PCD File #VR-22-003

**RE: Letter of Intent – Proposed Replat of Parcel Nos. 5312402015, 5312402016, 5312403003, 5312403004, 5312404003, 5312405003, 5312405005**

Unresolved - dsdschoenheit  
12/19/2022 6:25:53 PM

SHEET 3 OF 4

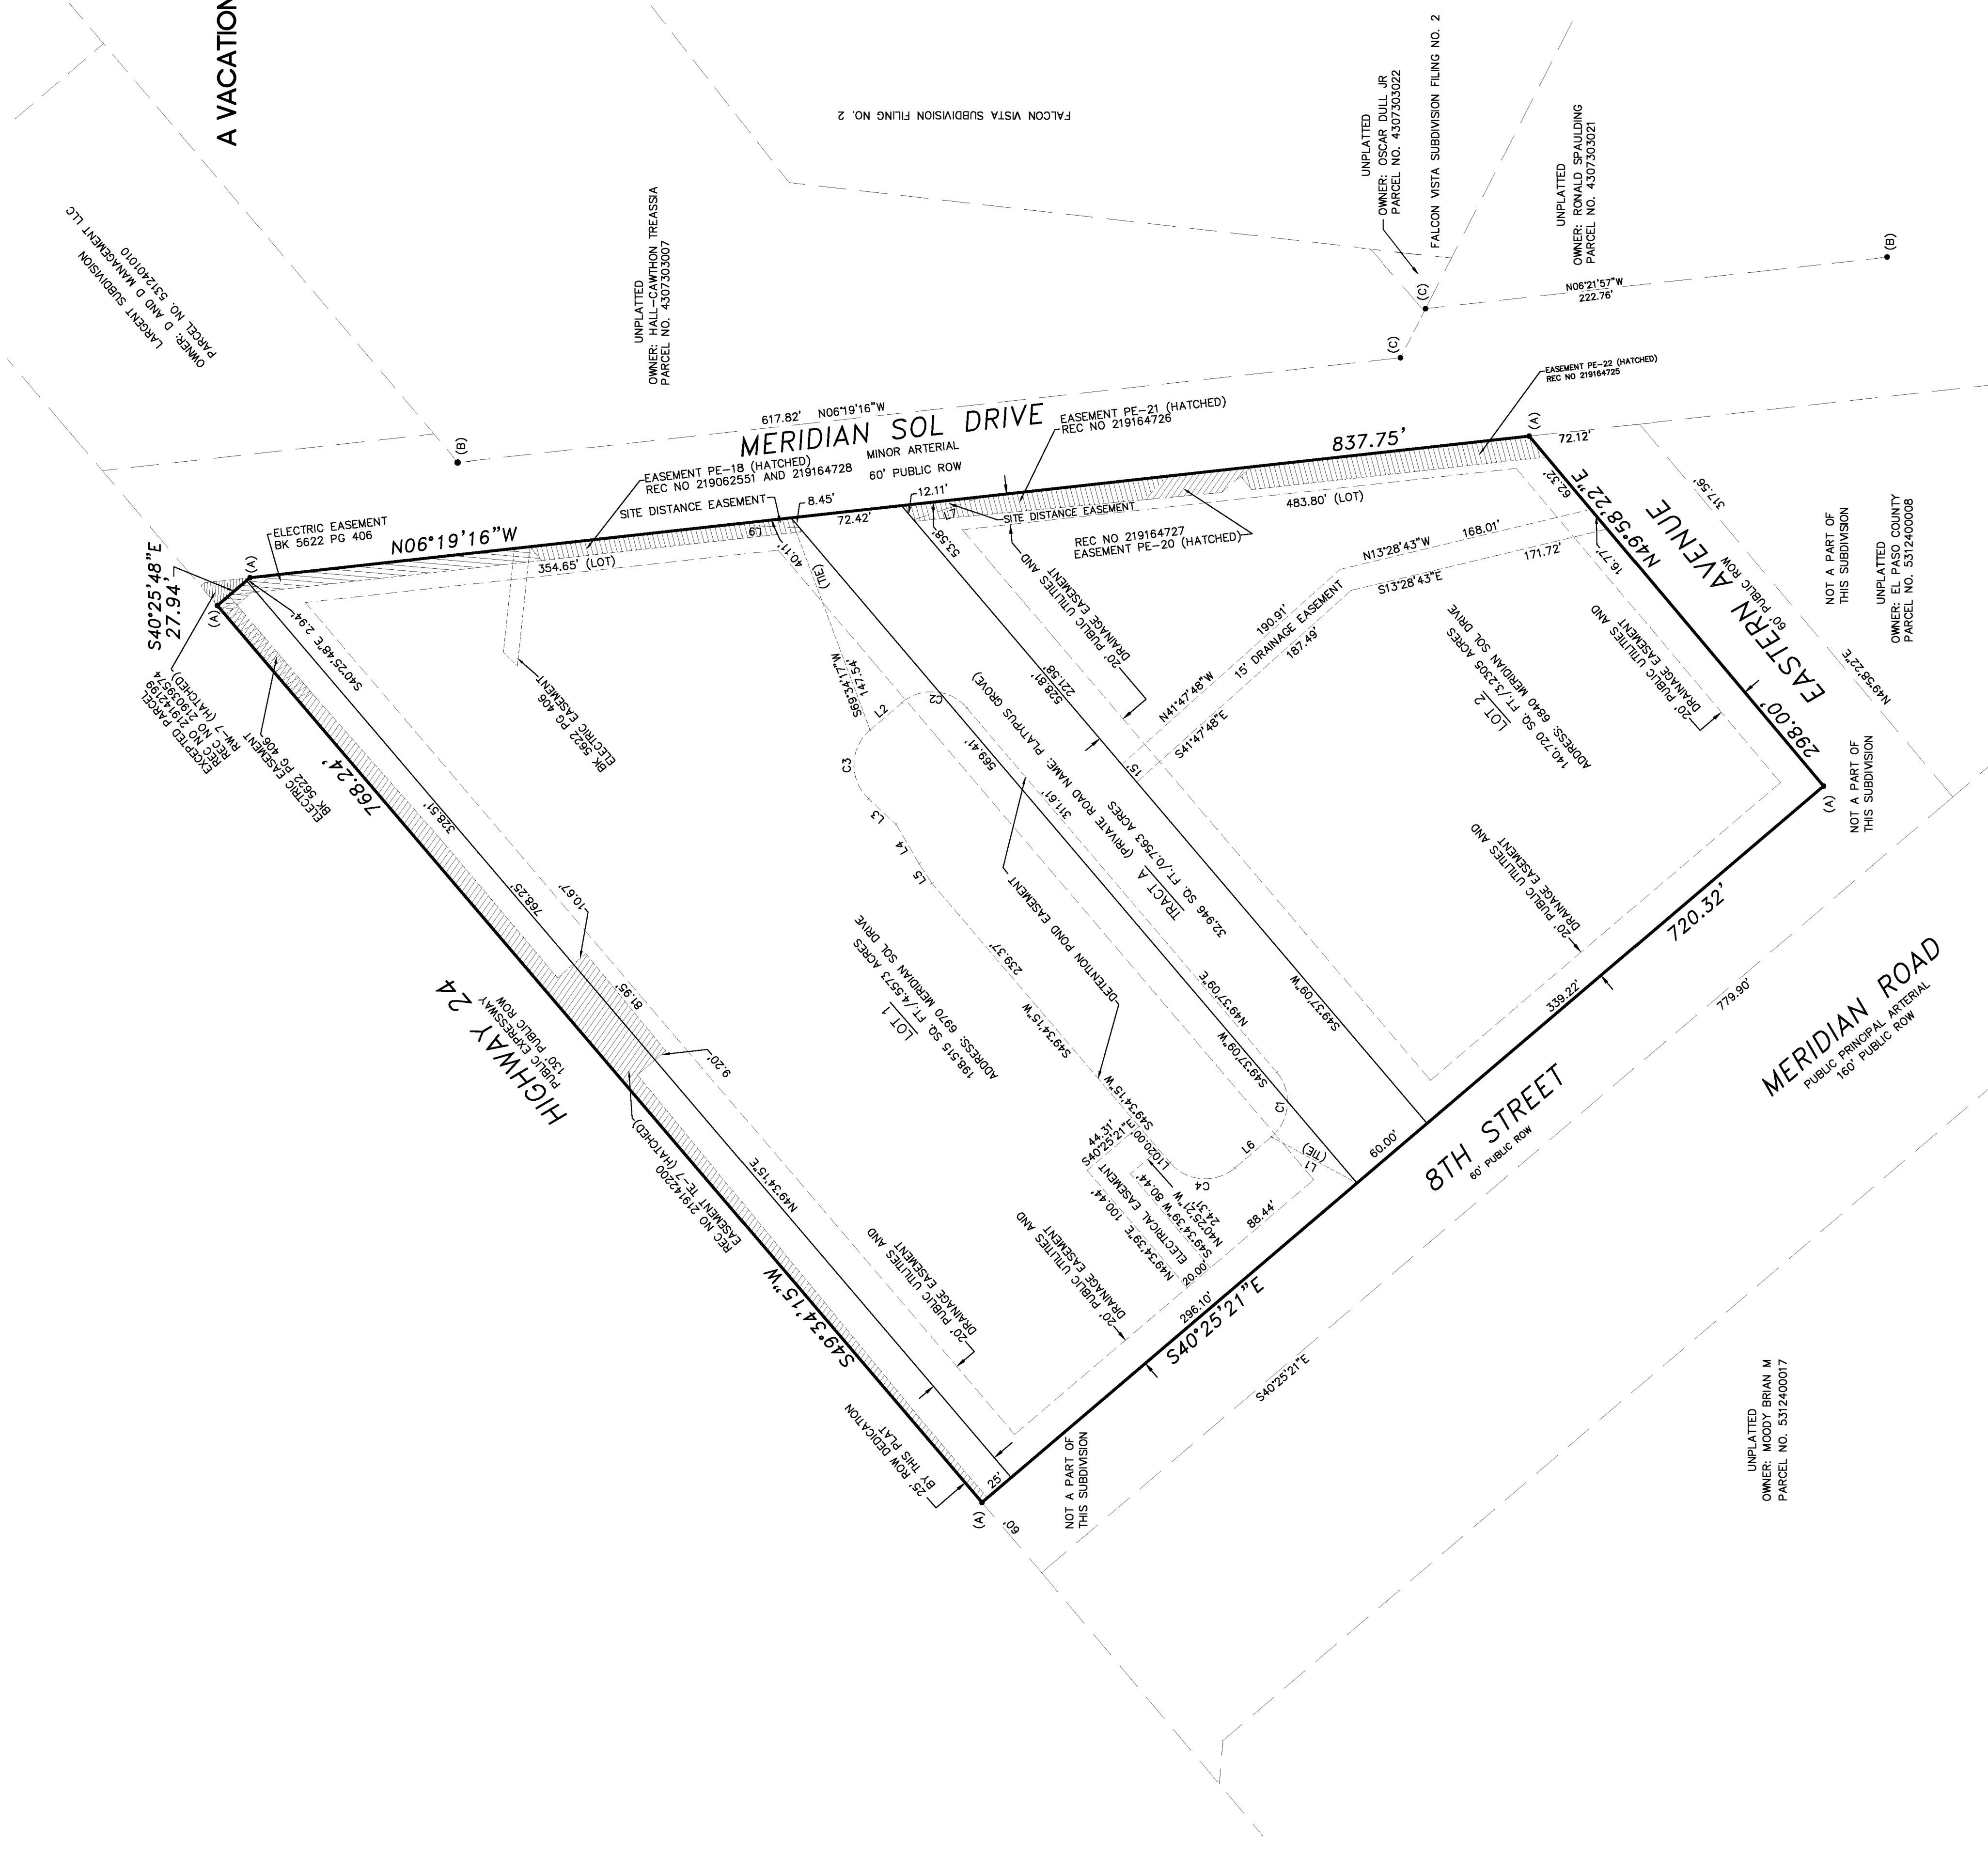
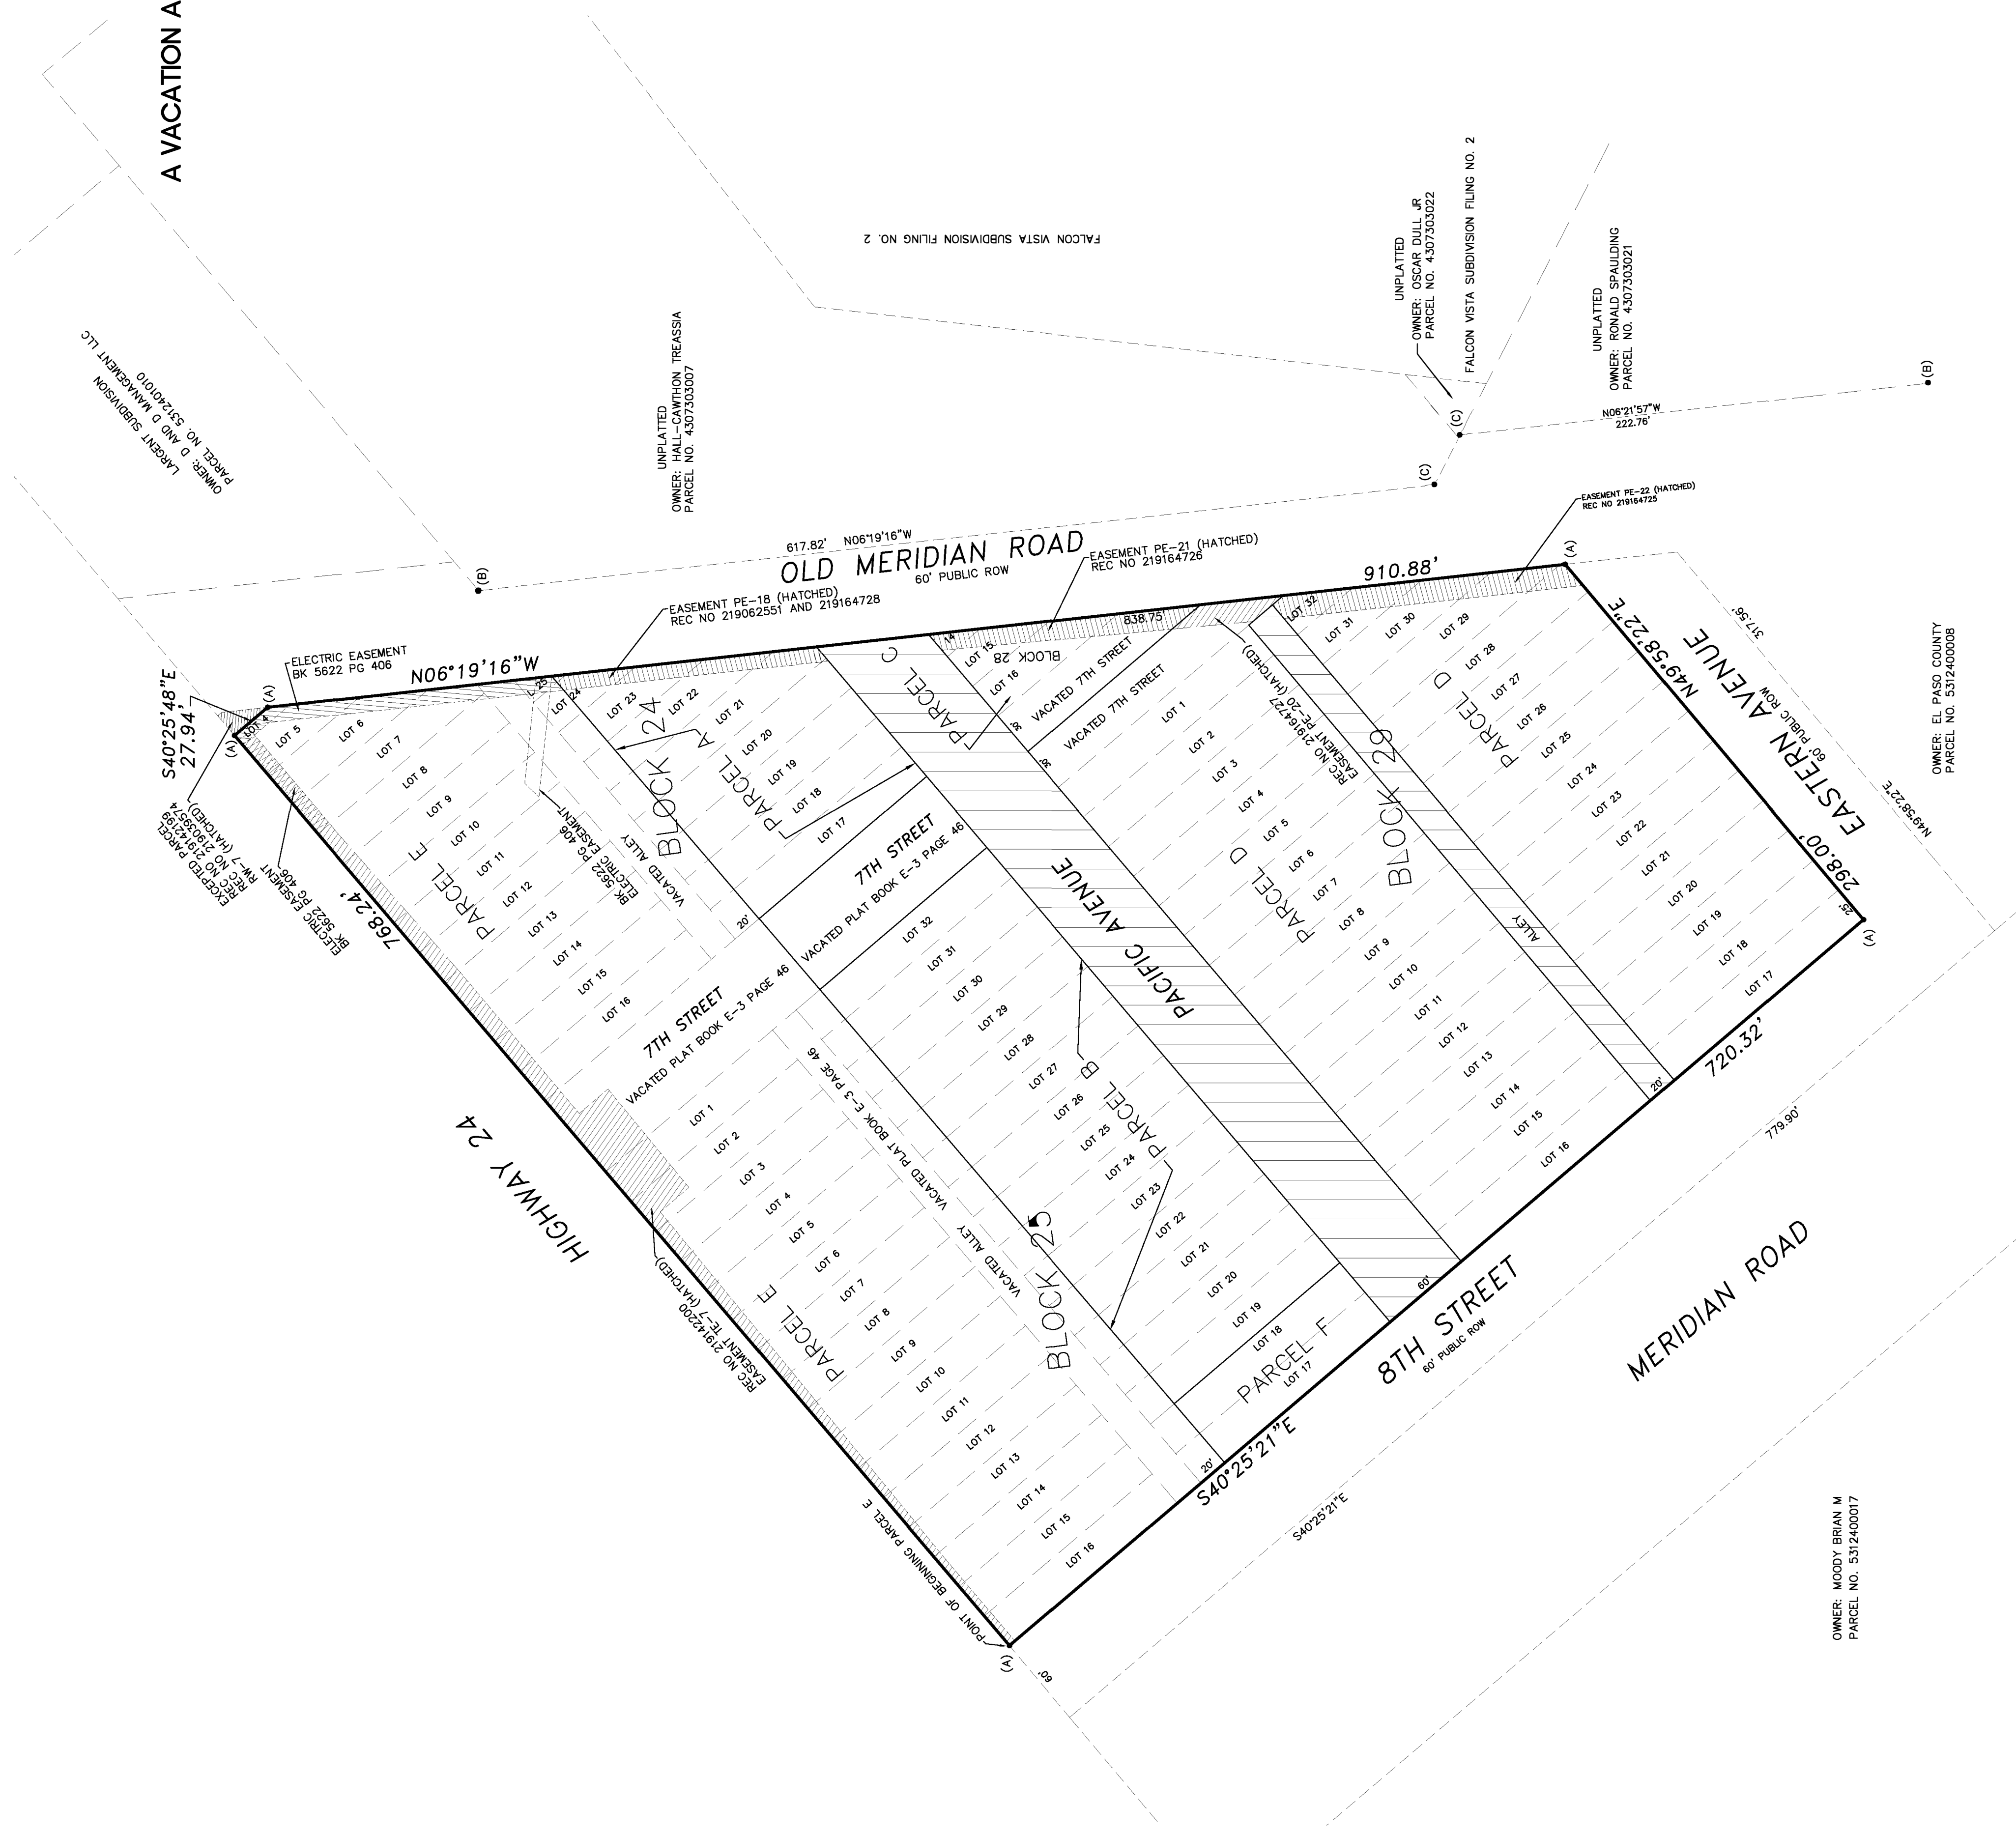
Page 2 of 4  
Add brief discussion detailing the areas of County ROW that is being requested for vacation from Plat 563 i.e Pacific Ava 60ft ROW and Alley 20ft ROW

The ROW vacation needs clarification. It has changed from V1 plat

If you are going to request a waiver, please acknowledge the Code section you are requesting a waiver from. Sec. 8.4.4.C requires public roads. Please also see comments on the plat regarding the vacation of the public ROW. If you are going to request a waiver, you also need to provide justification of the waiver review criteria Sec. 7.3.3.
